SUNCADIA PHASE 3 DIVISION 14 (LP-18-00002)

TO: Kittitas County Board of County Commissioners
FROM: Lindsey Ozbolt, Planning Official
RE: Suncadia Division Phase 3 Division 14 Preliminary Plat (LP-18-00002)
DATE: August 7th, 2018 [public hearing date]

JOB NO.:	998-722-017
DWG. NAME:	PP-02
DESIGNED BY:	JJH
DRAWN BY:	LGB
CHECKED BY:	
DATE:	03/19/2018
PRINT DATE:	
SHEET	
PP-02

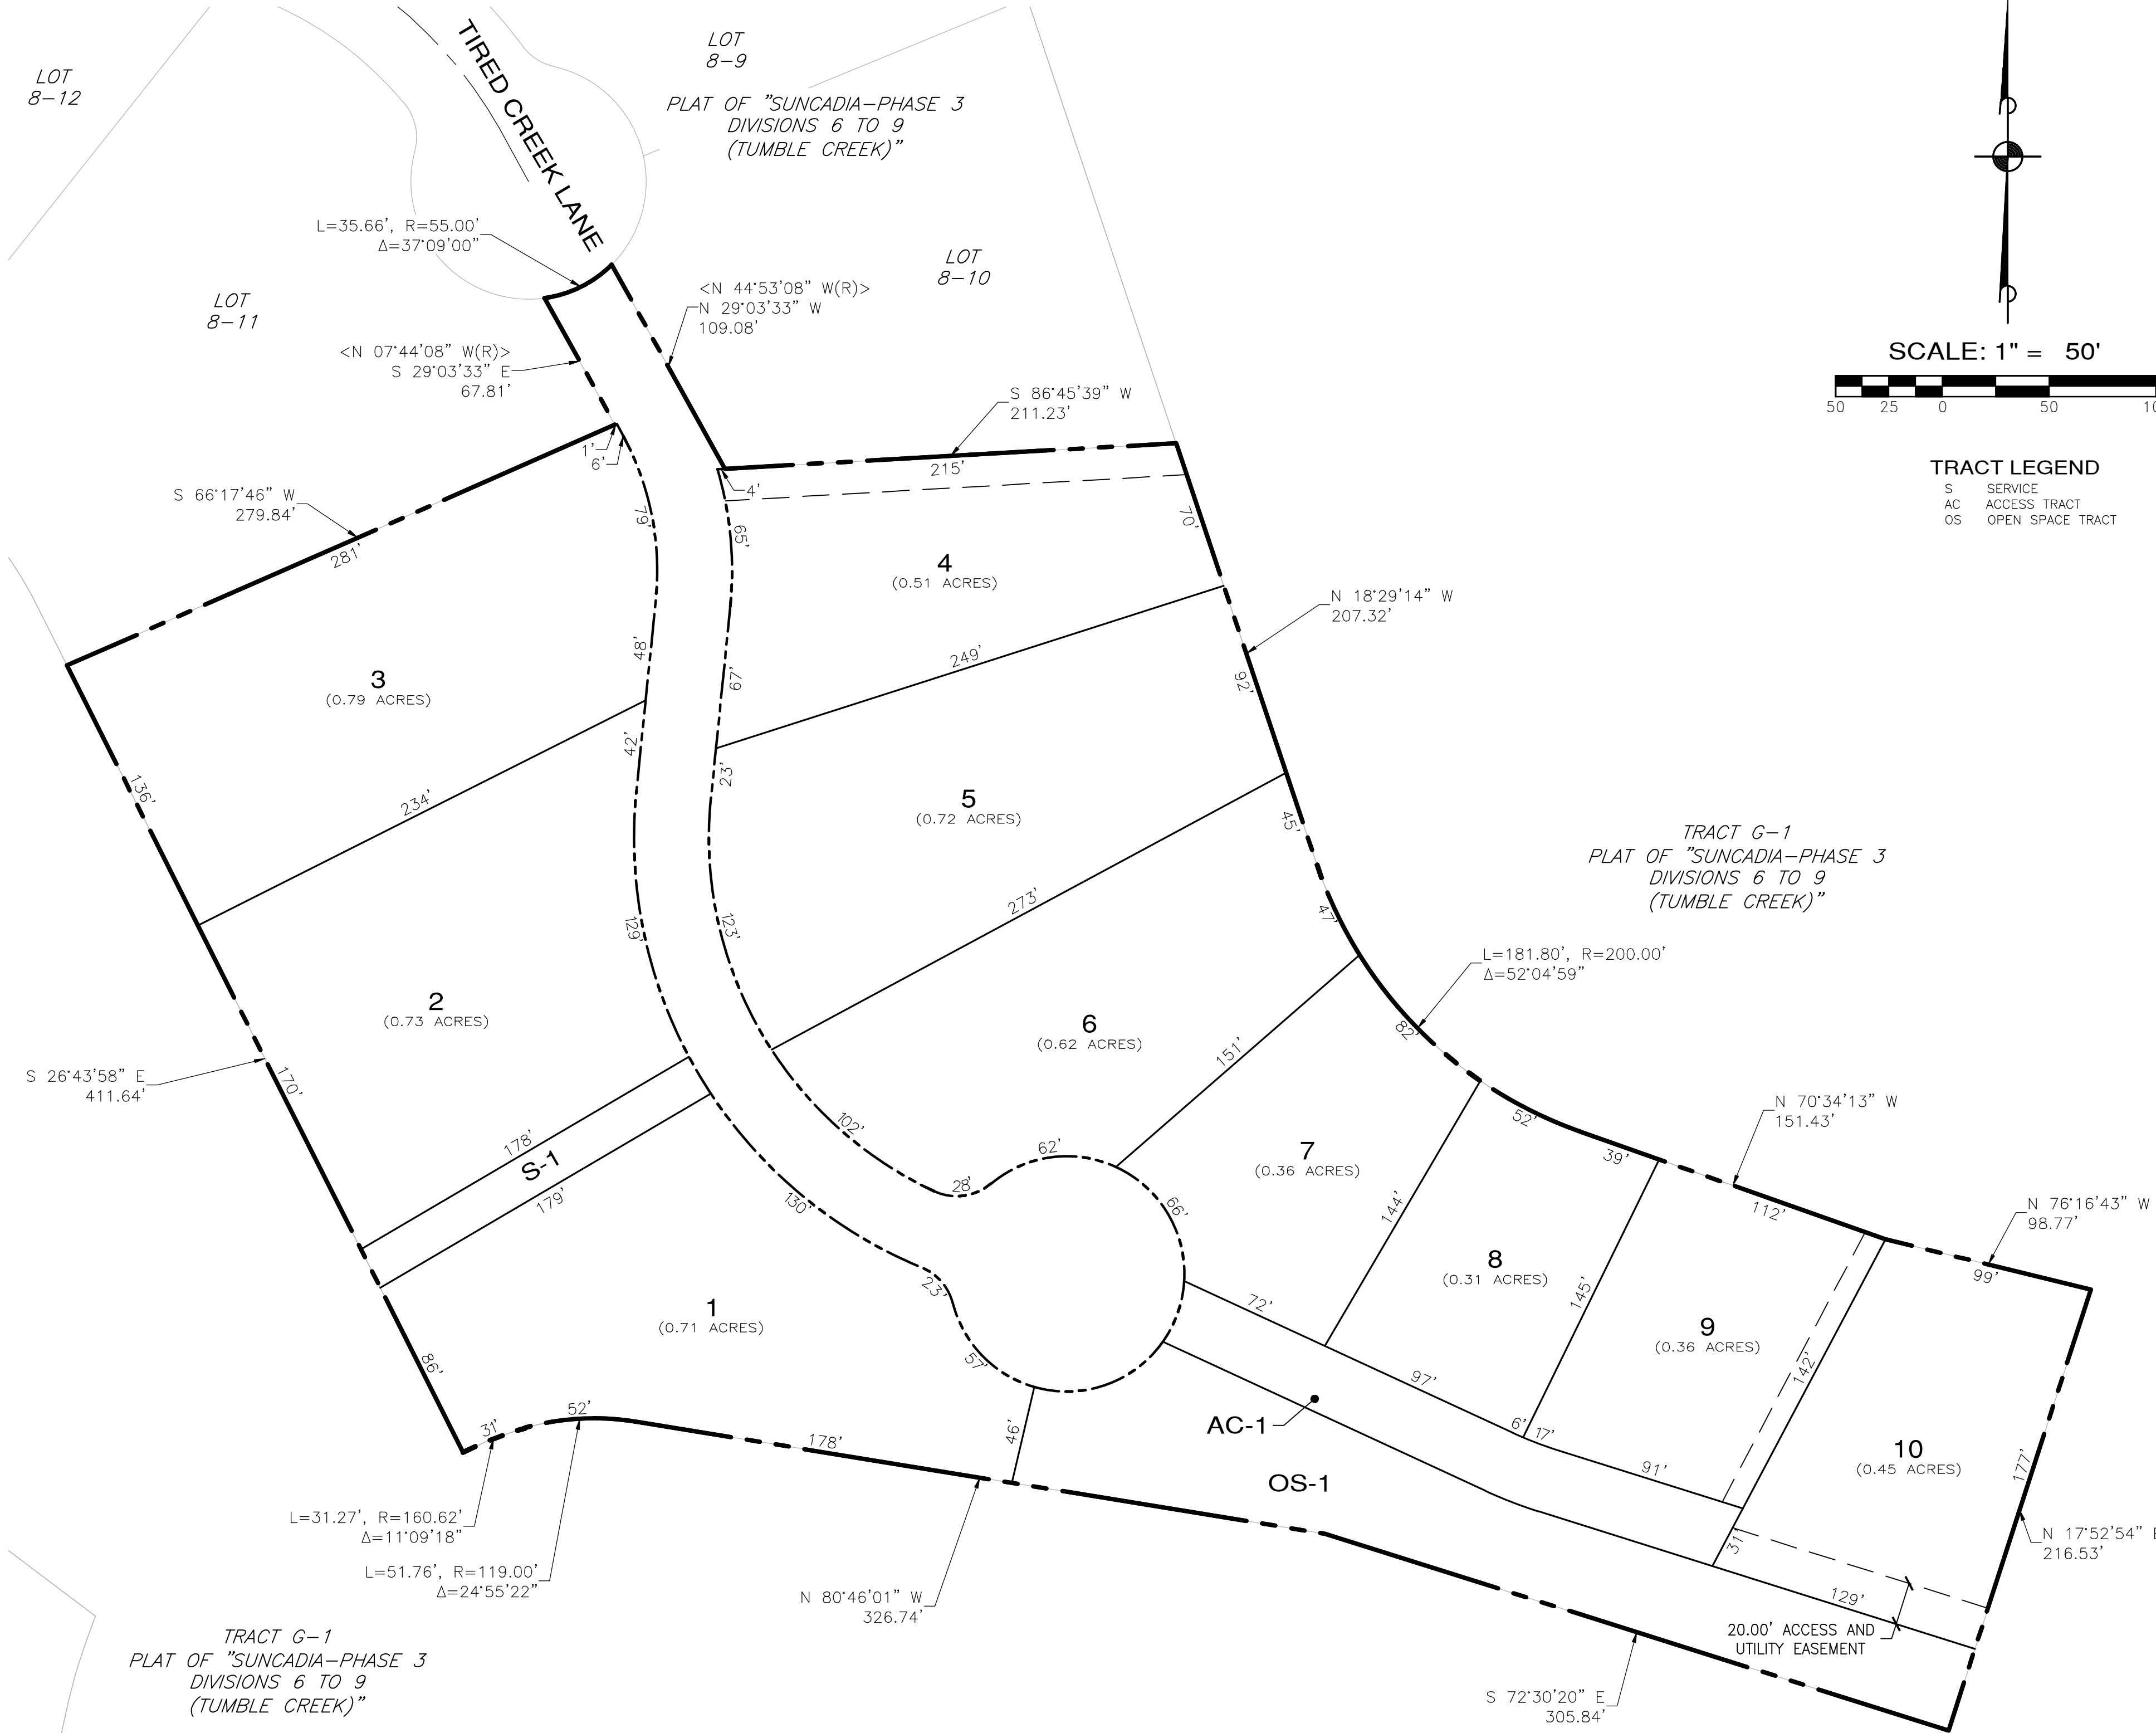
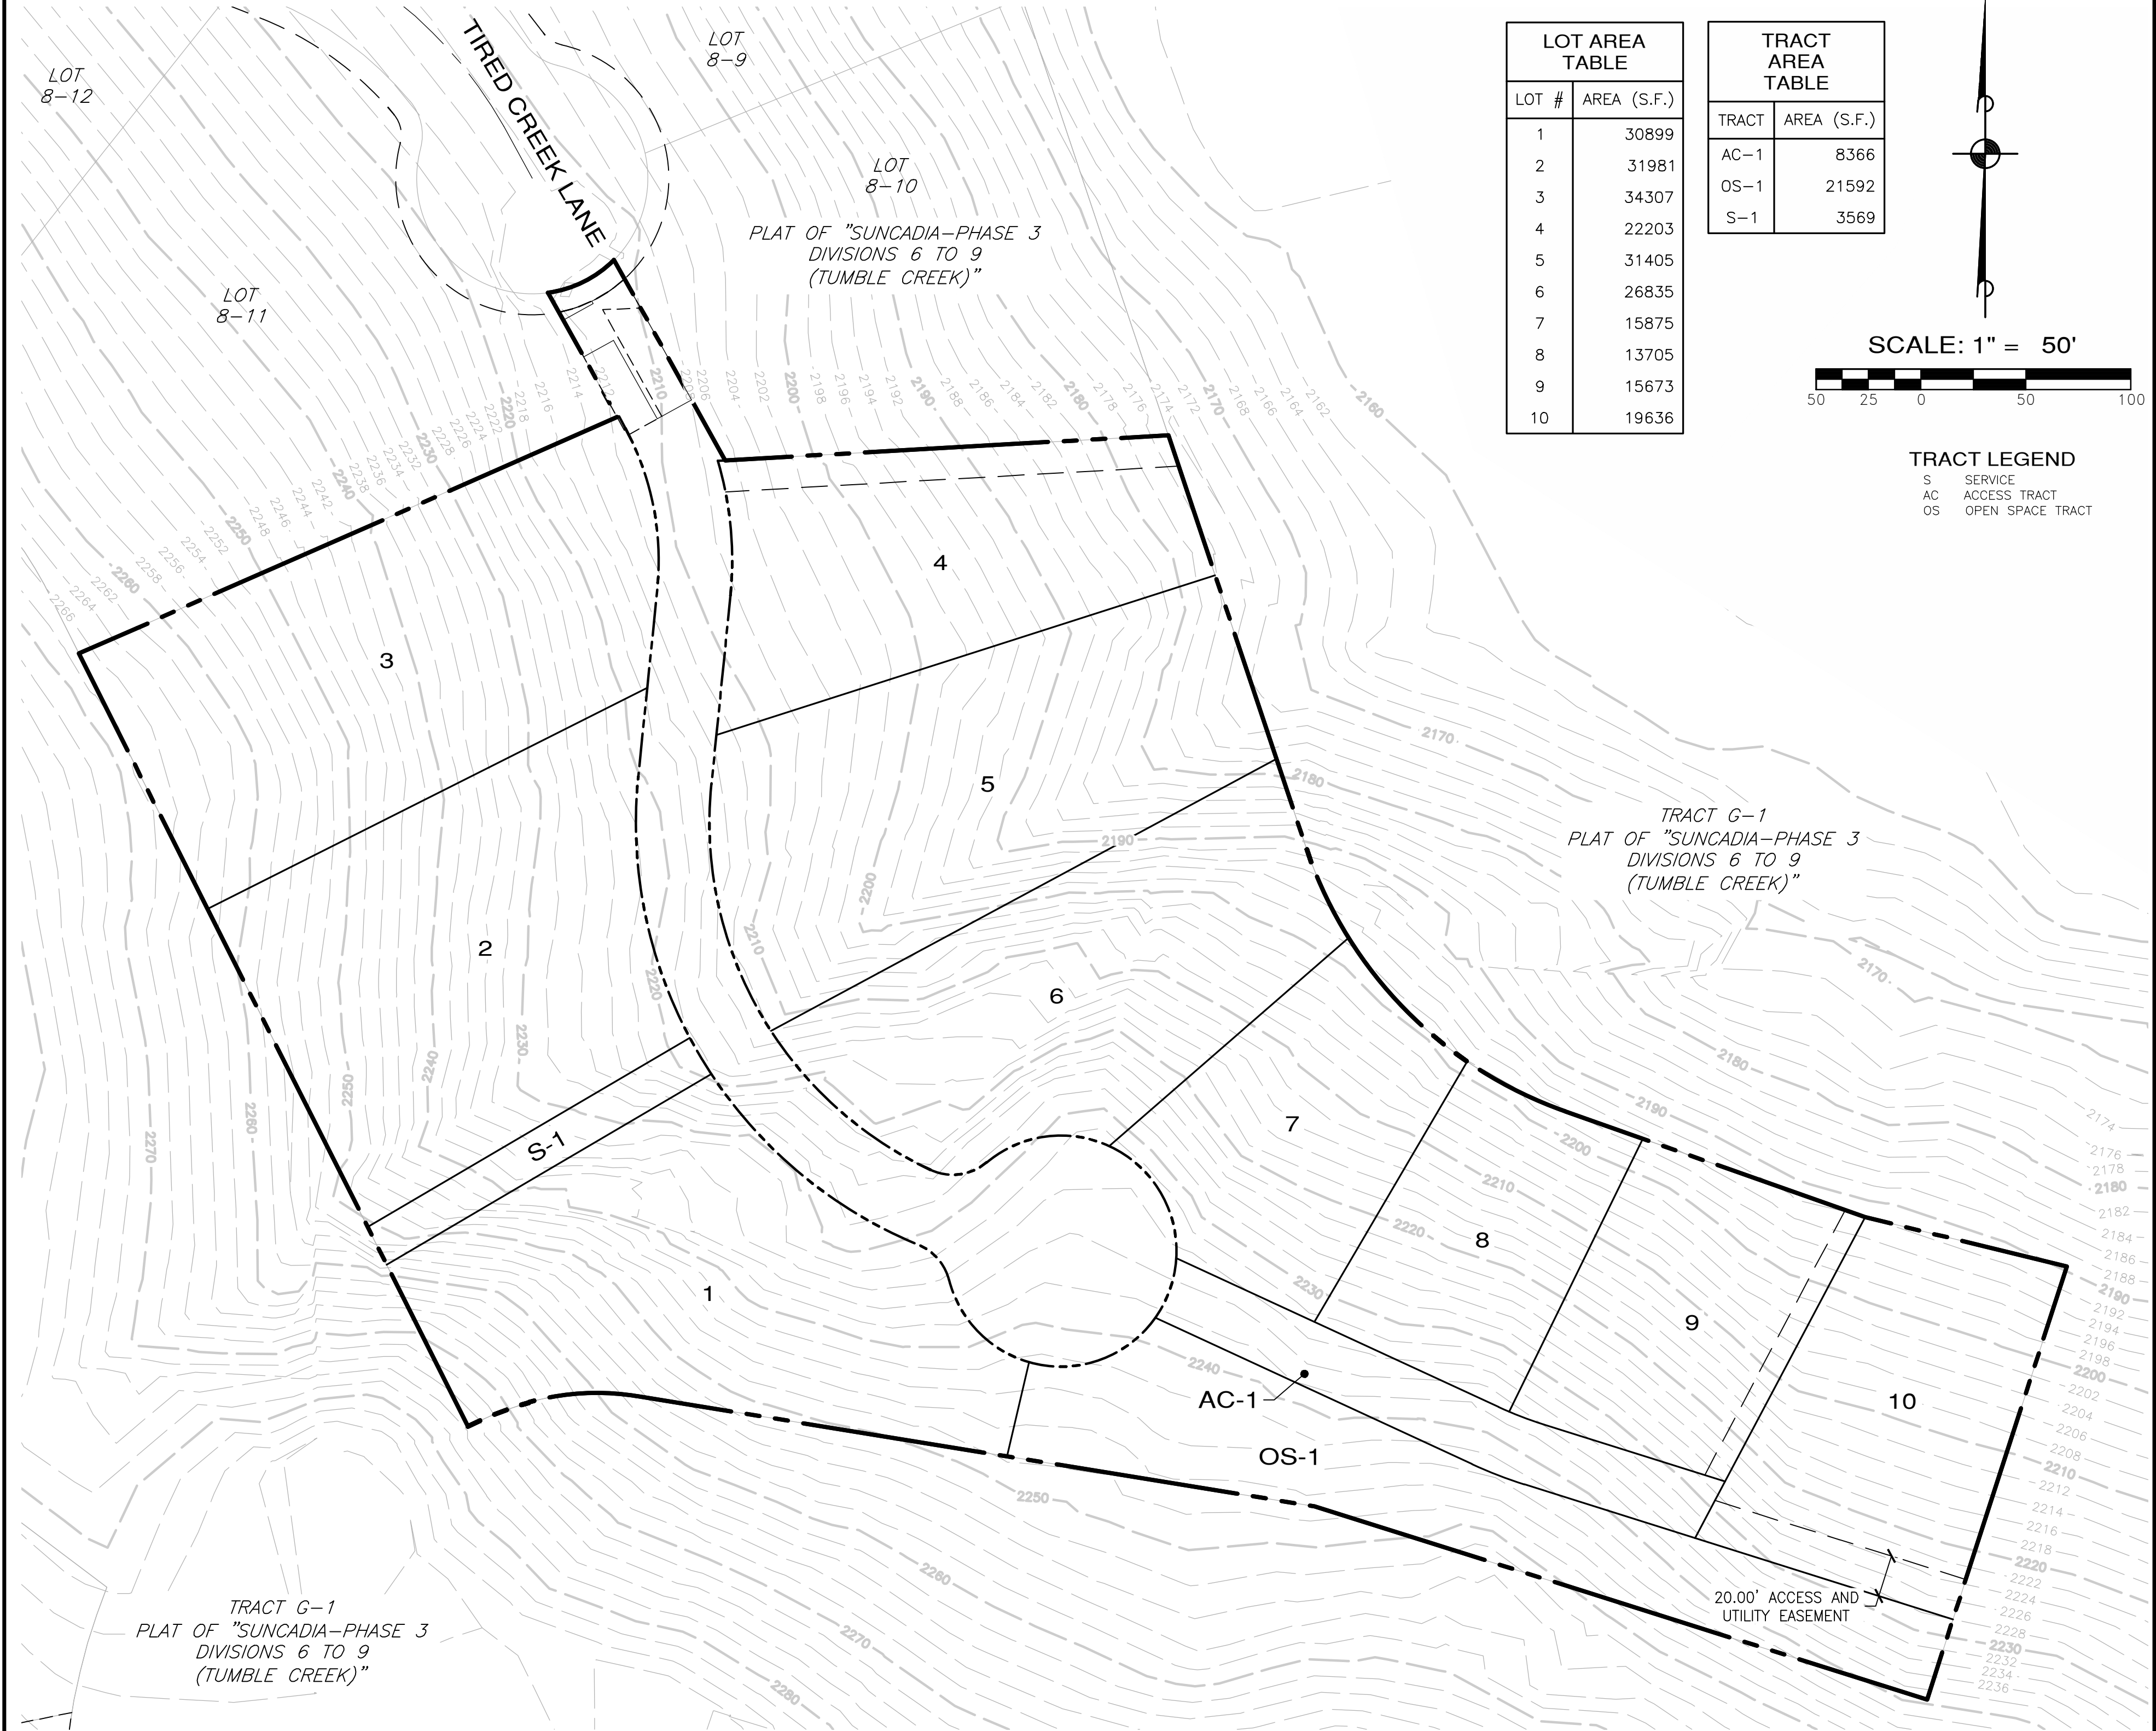
1. The preliminary plat must include a stamp from a licensed land surveyor on all sheets;
2. All pages must include page number and total number of pages;
3. The intended ownership limits of Lot 10 / AC-1 is unclear. Is AC-1 intended to be 20' wide or 30' wide?;
4. Tired Creek Lane should include width, ownership and surfacing; and
5. The lot area tables should include 5-1, AG-1 and OS-2.

Staff Response: Applicant provided a response to PW comments, included as Index #27 of the Master File. The applicant will adhere to all applicable regulations as outlined in the Development Agreement. Revised preliminary plat drawings were submitted and included as Index #30. Staff agrees with the applicant provided response.

8. The Final Plat shall contain the page number and total number of pages on all sheets.
9. The intended ownership limits of Lot 10/AC-1 is unclear. This shall be clarified prior to final plat approval.

10. Tired Creek Lane shall include width, ownership, and surfacing on the Final Plat. (EX: Tired Creek Lane – 30' wide private R/W-Paved)
11. The lot area tables on the Final Plat shall include S-1, AG-1, and OC-1.
